757 Congress Street Carriage House

Life Safety CEO / Plan Reviewer
Permitting and Inspections Department
City of Portland
389 Congress Street
Portland, Maine 04101
Phone:(207) 756-8187

Second Floor Plan

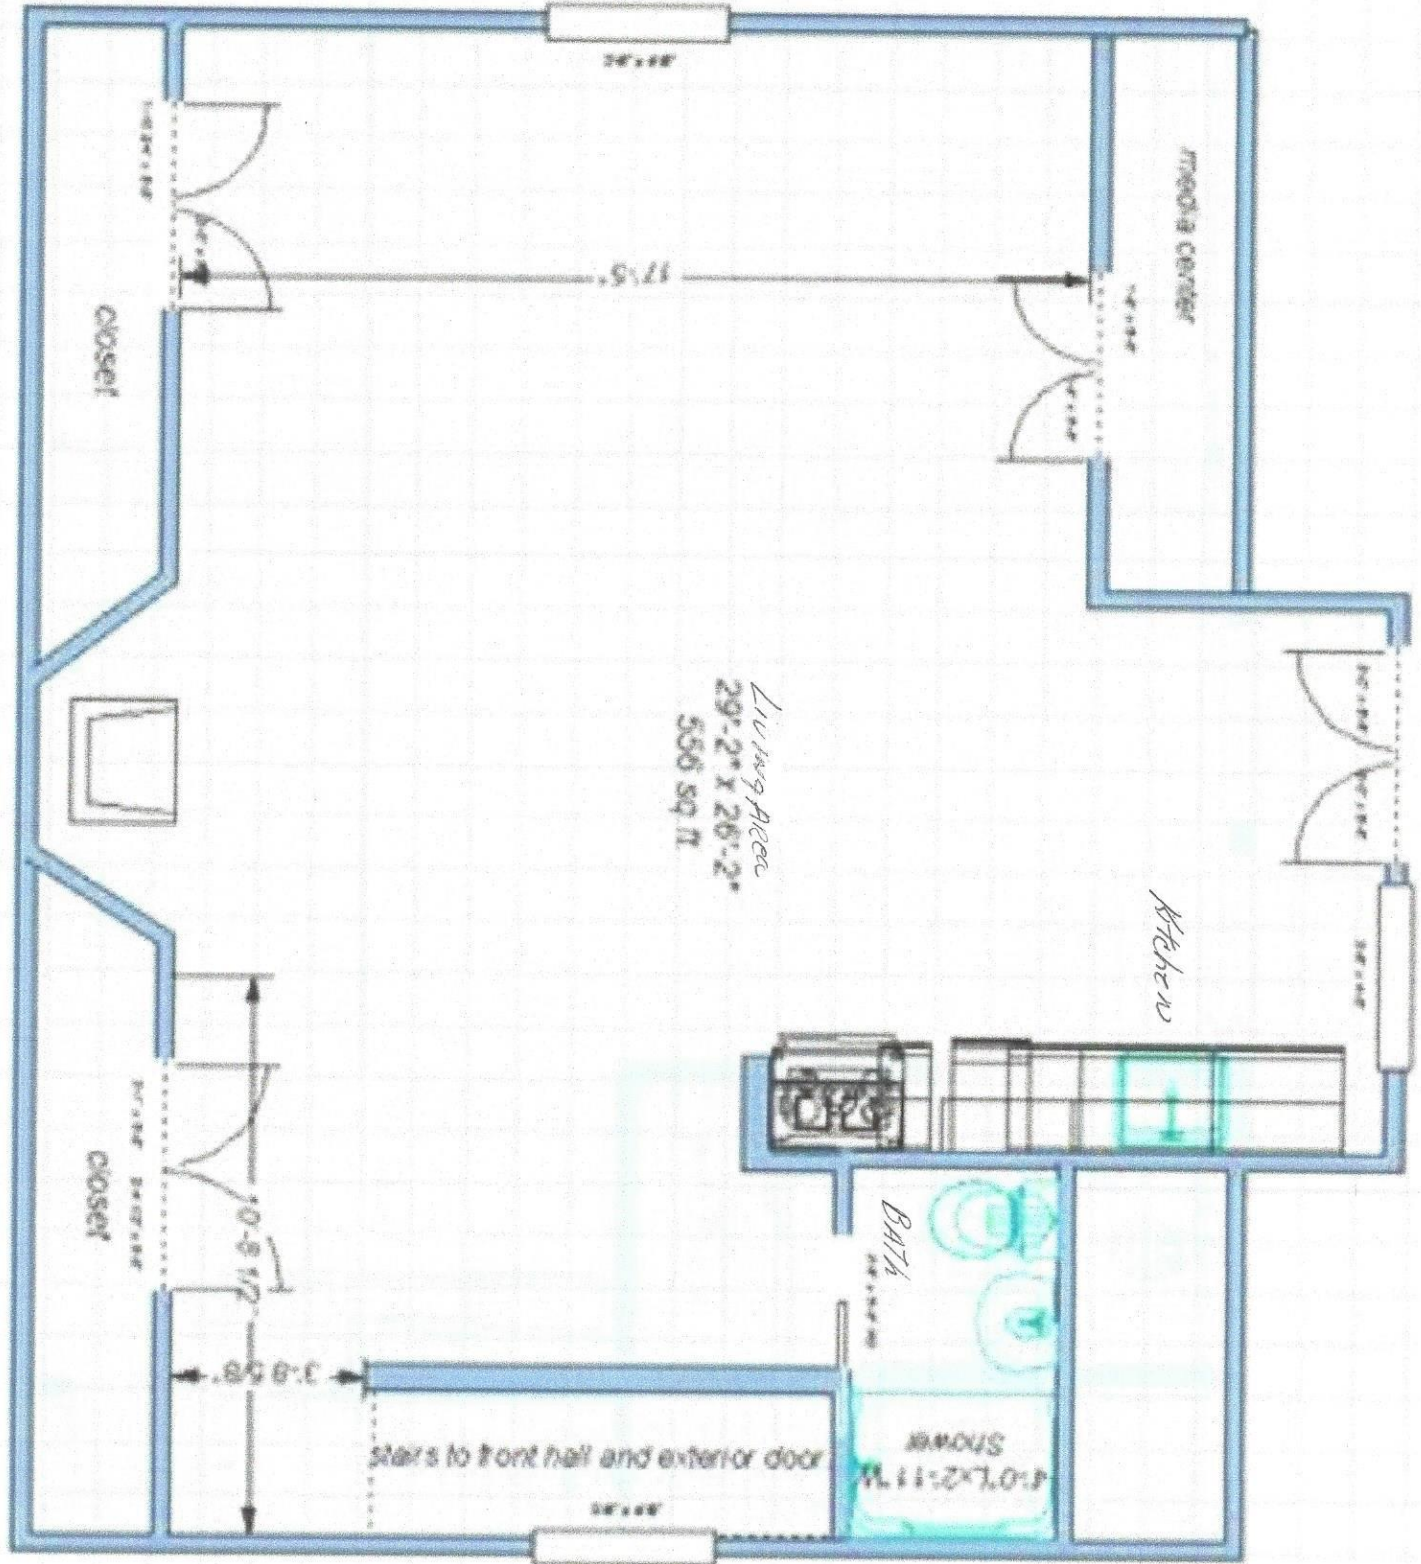
Are the windows in the new bedrooms new wall openings? If so the new windows will need to be egress windows that meet the following criteria:

The secondary means of escape may be an outside egress window operable from the inside without the use of tools, keys or special effort. Egress windows shall provide a clear opening of not less than 5.7 Sq. Ft. The width shall not be less than 20 inches, and height shall not be less than 24 inches. The bottom of the window opening shall not be more than 44 inches above the floor (NFPA 101 Ch 24.2.2.3.3).

Yes and I thought that is mentioned on the first page. Both windows will meet the criteria you just mentioned
